R/102/22/L

Elm Farm 34 The Street Rustington BN16 3NX

Listed building consent to install a single person lift.

Project: Proposed lift; Elm Farm, 34 The Street, Rustington BN16 3NX	
Drawing: Ground floor proposed	
For: Mr. & Mrs. J. Tanzer	
Drawn: PKS	Date: May 2022
Scales: 1:100	No: 2948/01/03
To scale when printed on A3

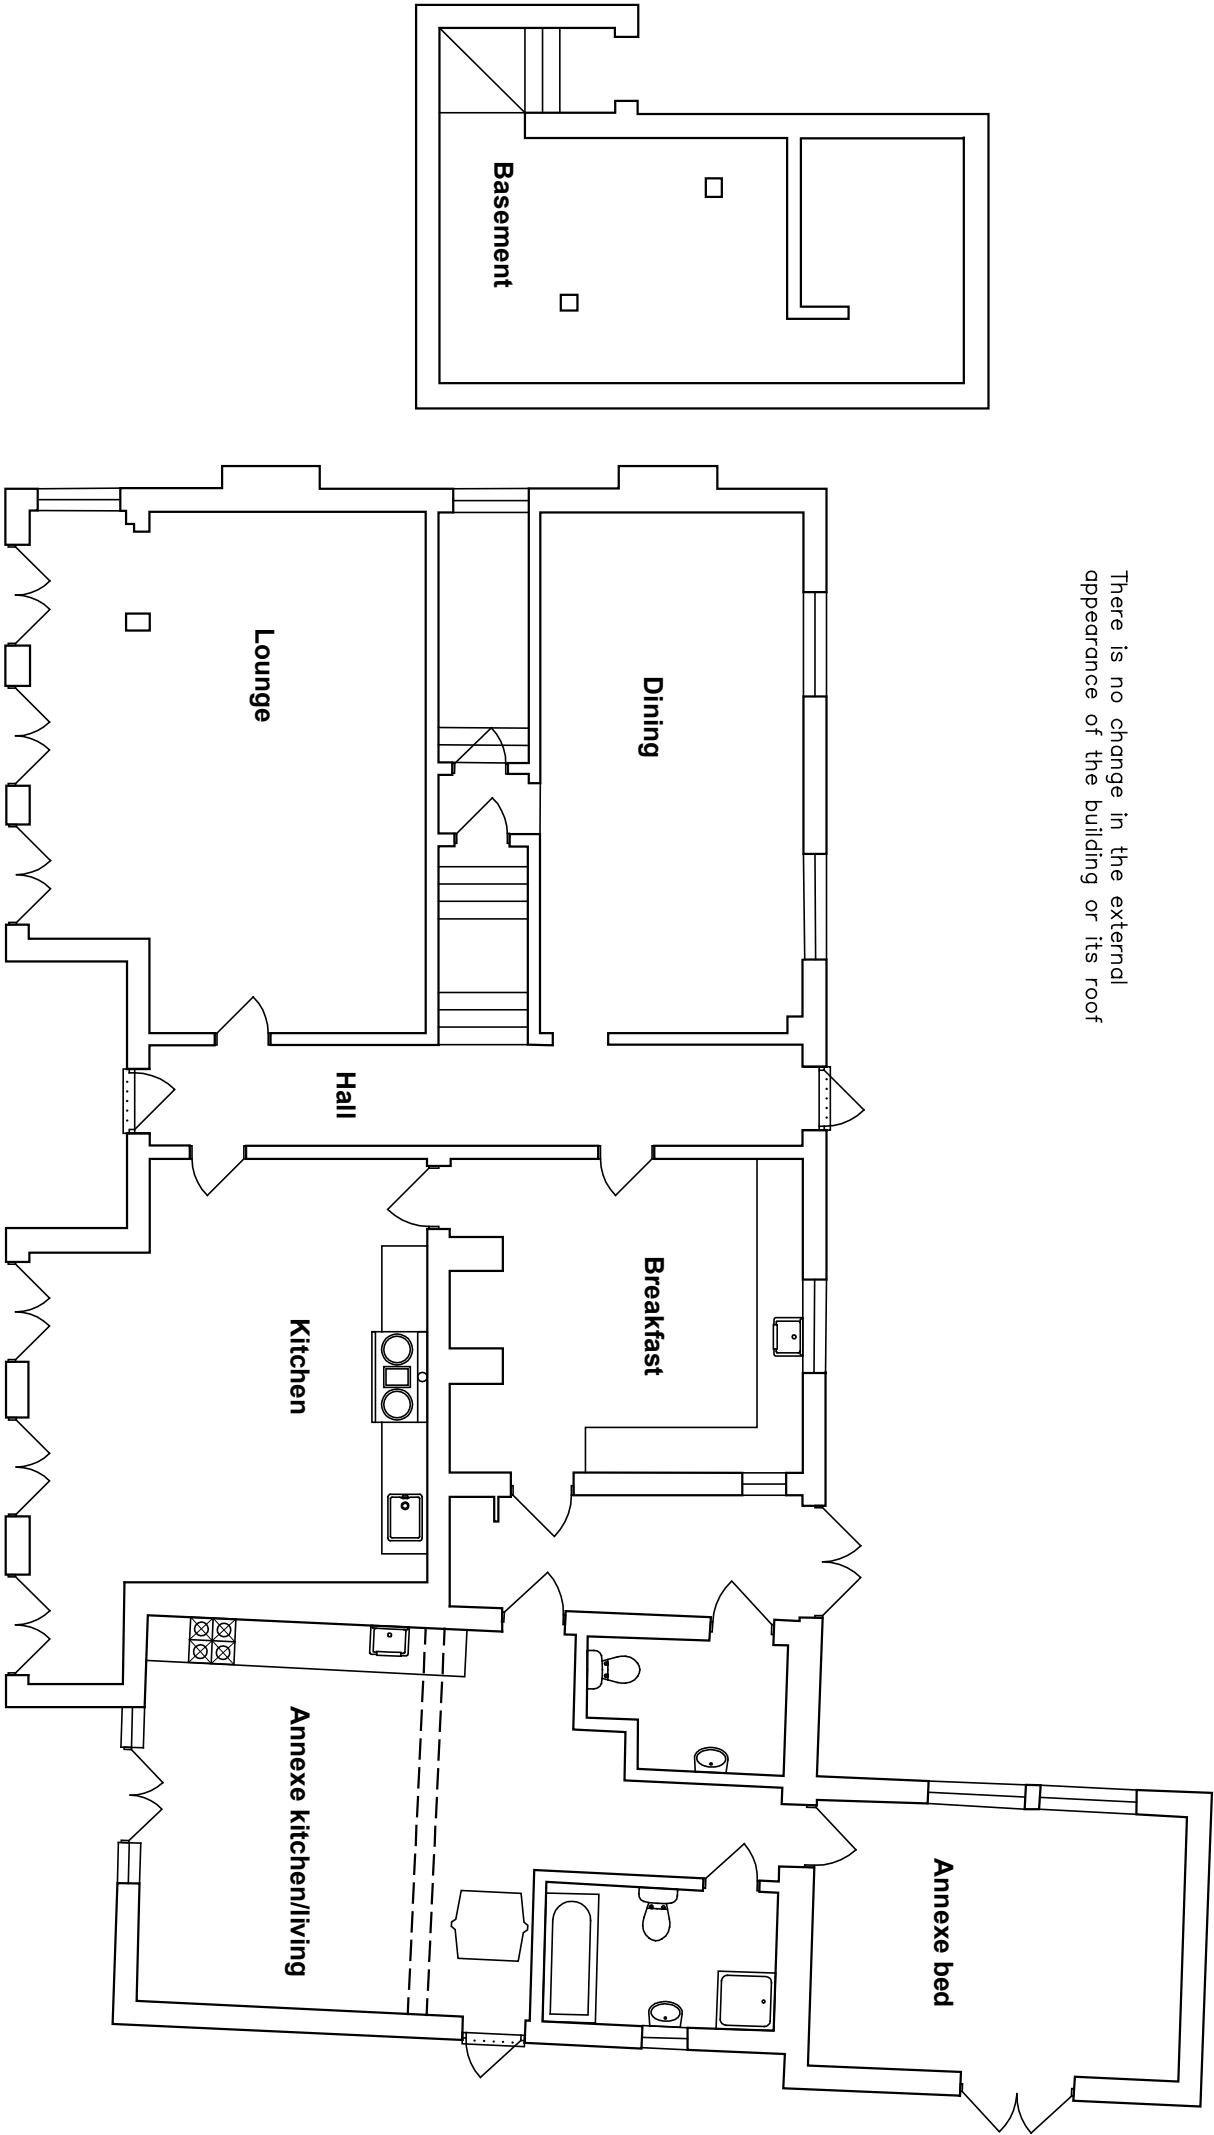
The proposal involves the removal of the existing stairs in the annex and the studio, and the installation of a small lift. When I previously visited the house, it was clear that the location of the proposed lift (and the existing staircase) affects relatively modern fabric and that its loss/alteration would be acceptable. It would also appear that the intention is to utilise the stair-well which would mean that less fabric is removed from the house.

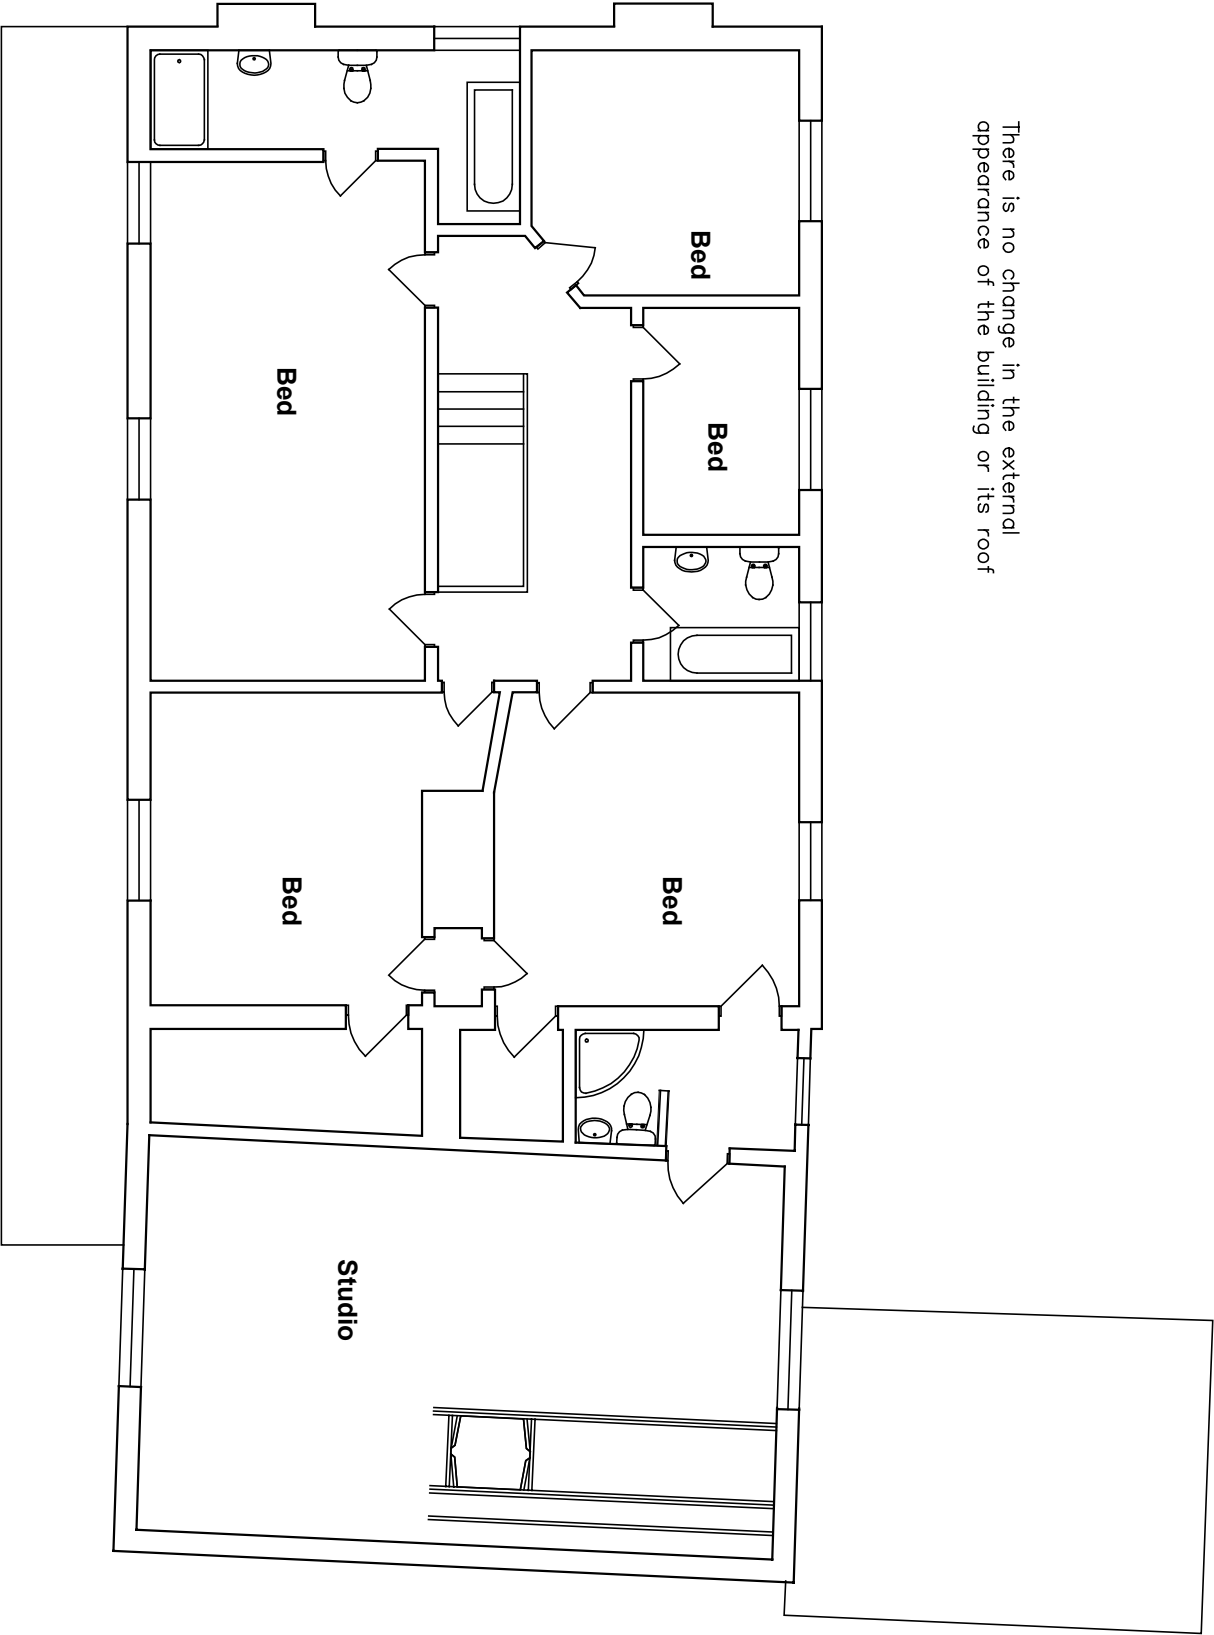
The design of the lift, whilst basic, is also such that it would not overly dominate the room. This is partly based on its size and that of the first floor room it is to service. However, at present, the proposed first floor plans are not clear to me – for instance, what are the additional lines which stretch from the lift to the rear wall of the studio? Is this walling? If so, how will it be treated? Further information is required regarding this.

Based on a review of both the existing and proposed floor plans it is also not clear if a new doorway has been inserted between the rear en-suite and the studio space. When I visited the house recently, this opening was not present, and in fact it was a point of discussion when I was there – i.e. where could/should such an opening be located. If it has been constructed now, this was without the relevant consent, is unauthorised, and incredibly disappointing.
